From: Amanda Scholes on behalf of Planning.Responses
Sent: 22 May 2018 09:08
To: Planning Scanning
Subject: FW: Reserved Matter application BN/6/18/RES - The Lillies Former Caravan Park, Yapton Road, Barnham
Attachments: 180420 Lillies Sketch Option.pdf

Subject: Reserved Matter application BN/6/18/RES - The Lillies Former Caravan Park, Yapton Road, Barnham

Following the submission of the reserved matters application (BN/6/18/RES) for the former Lillies Caravan Site, it is considered that the proposed layout at the rear of the site needs to be amended to create sufficient useable open space within the application boundary.

Sketch Layout - 01

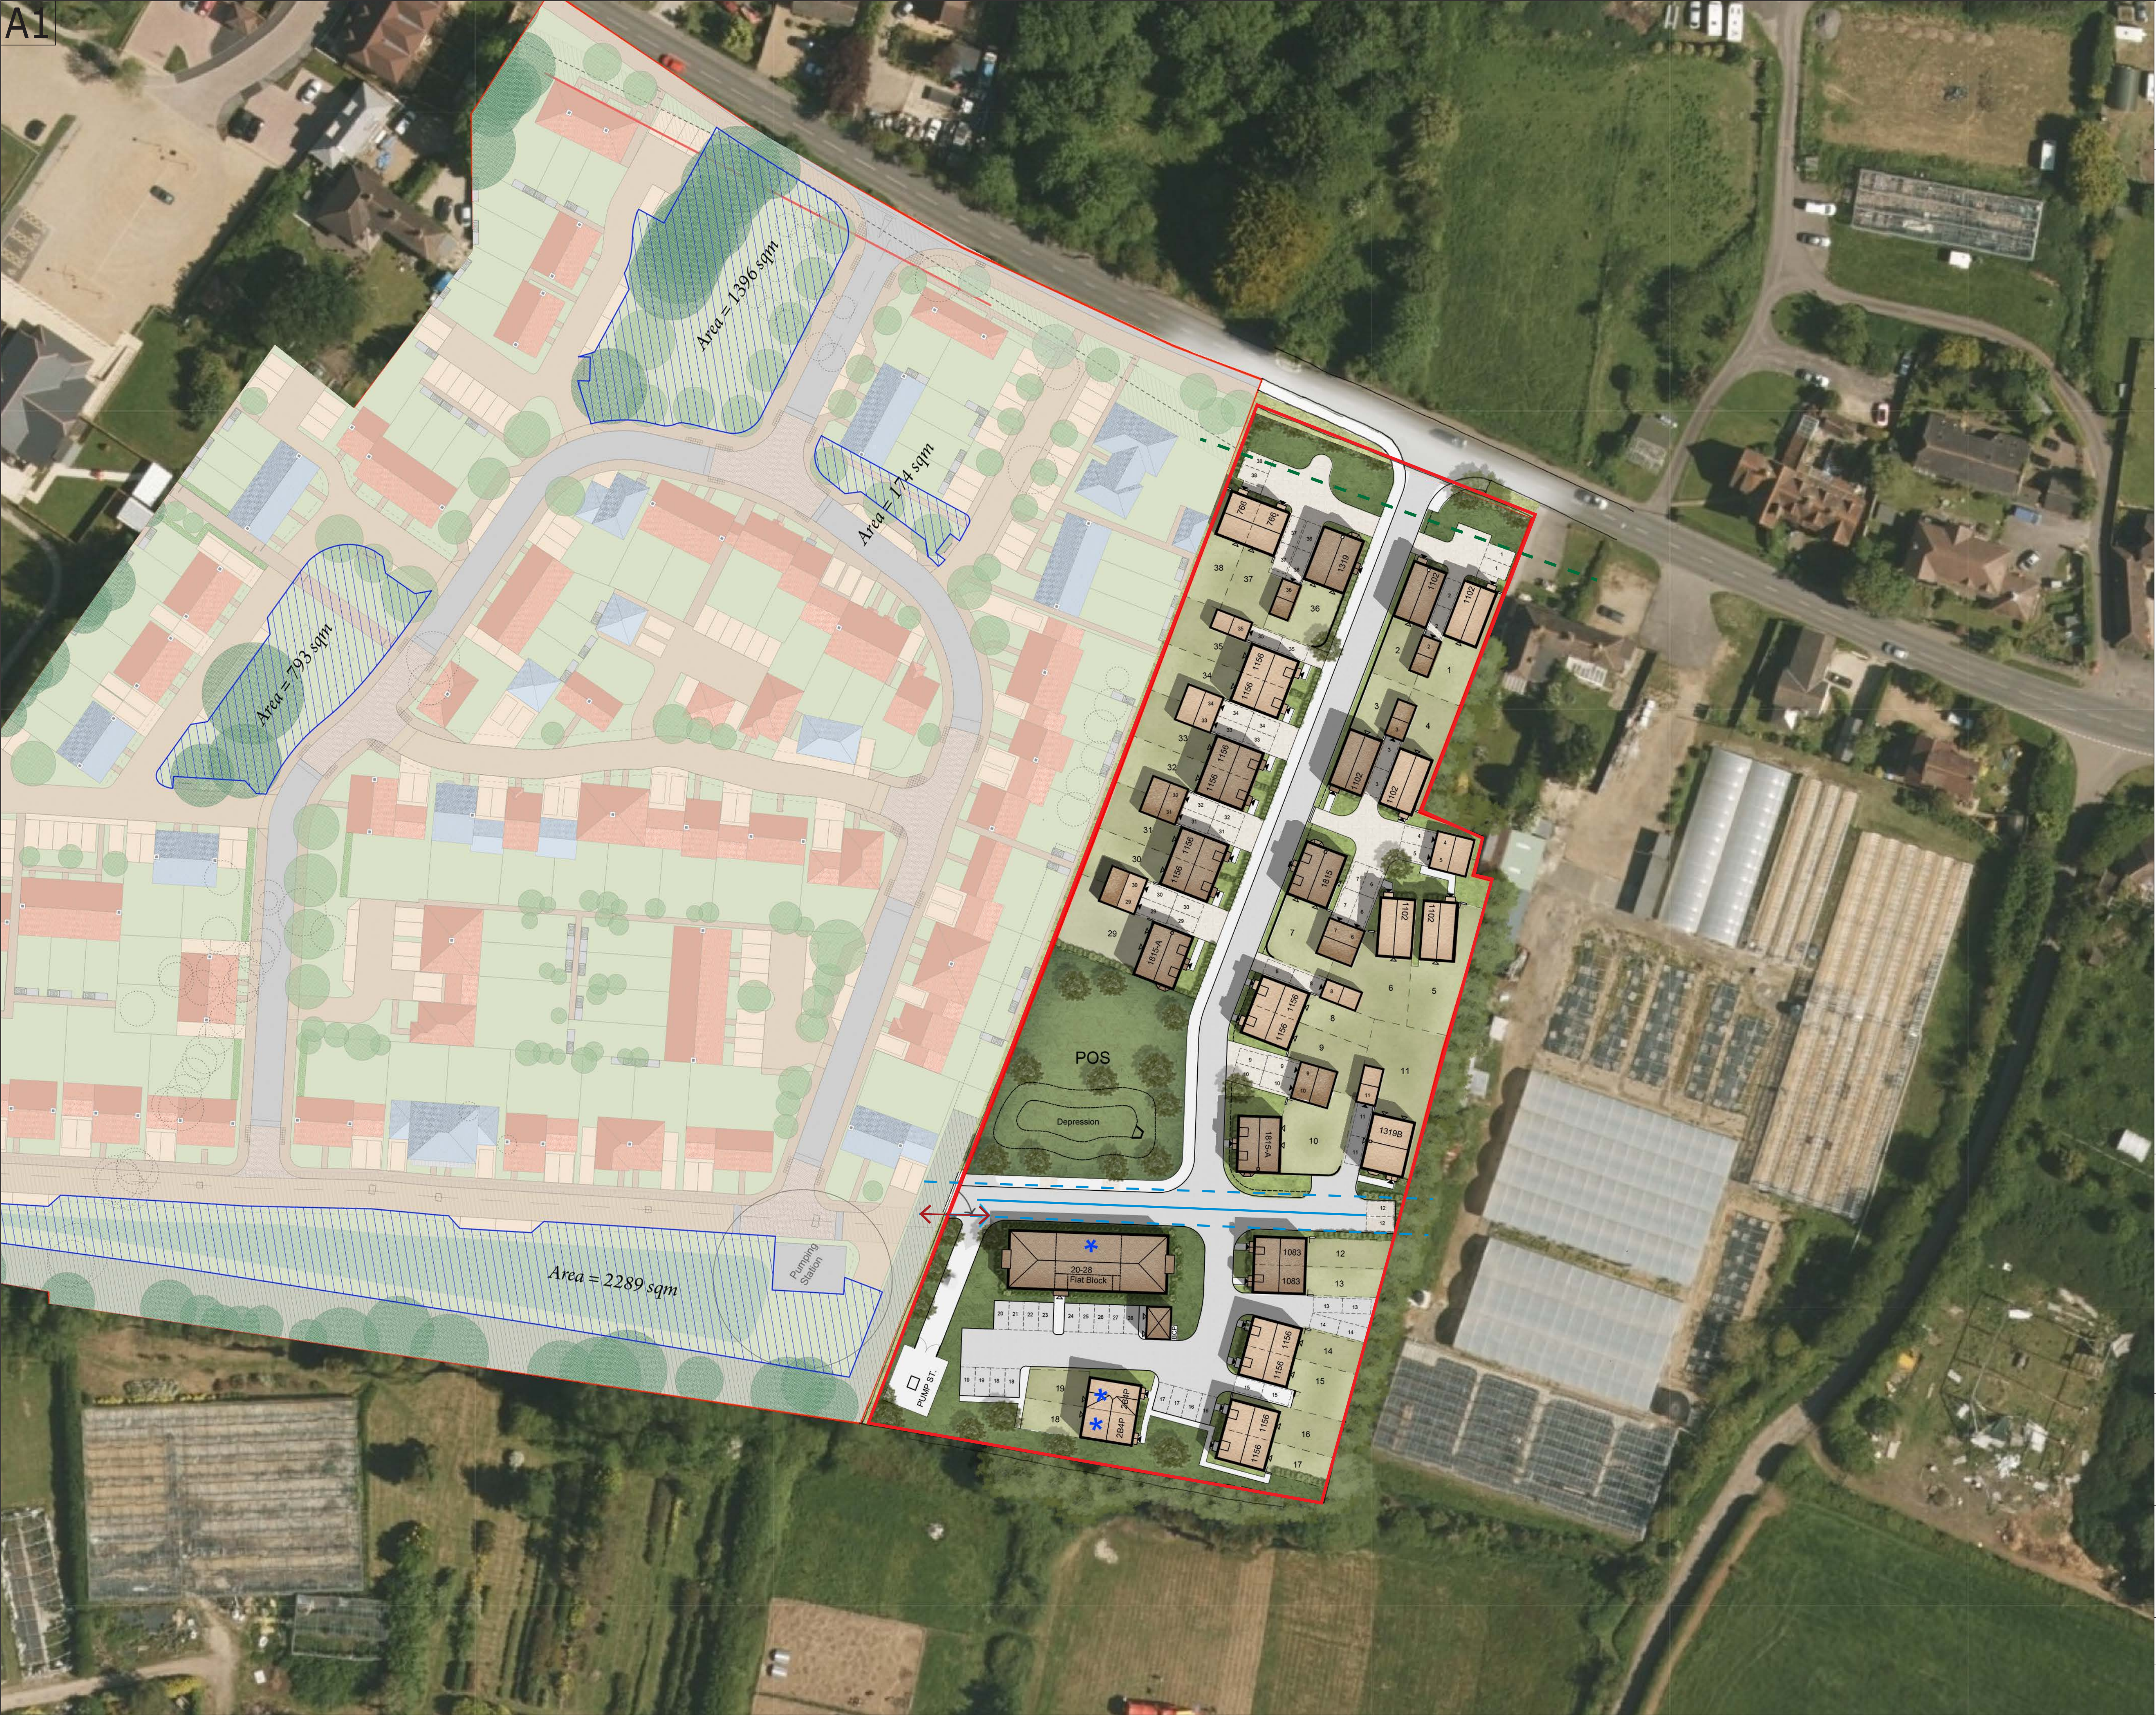
You are strongly advised to amend the submitted planning application by removing units numbers 18 and 19 from the proposed development; moving the apartment building back towards the rear of the site so as to provide sufficient useable open space in front of the apartment building; placing the car parking for the apartment building at the front of the building; and providing private amenity space to the rear of the apartment building.

Following on from your email below we have revised the scheme and I summarise as follows;

- Reworking of southern end of the site allowing relocation of flat block and parking
- Private amenity area added to rear of flat block
- Defensible space added around flat block with hedge planting
- Area of POS added adjacent to flat block
- POS area to centre of the site in line with principles consented under the outline consent
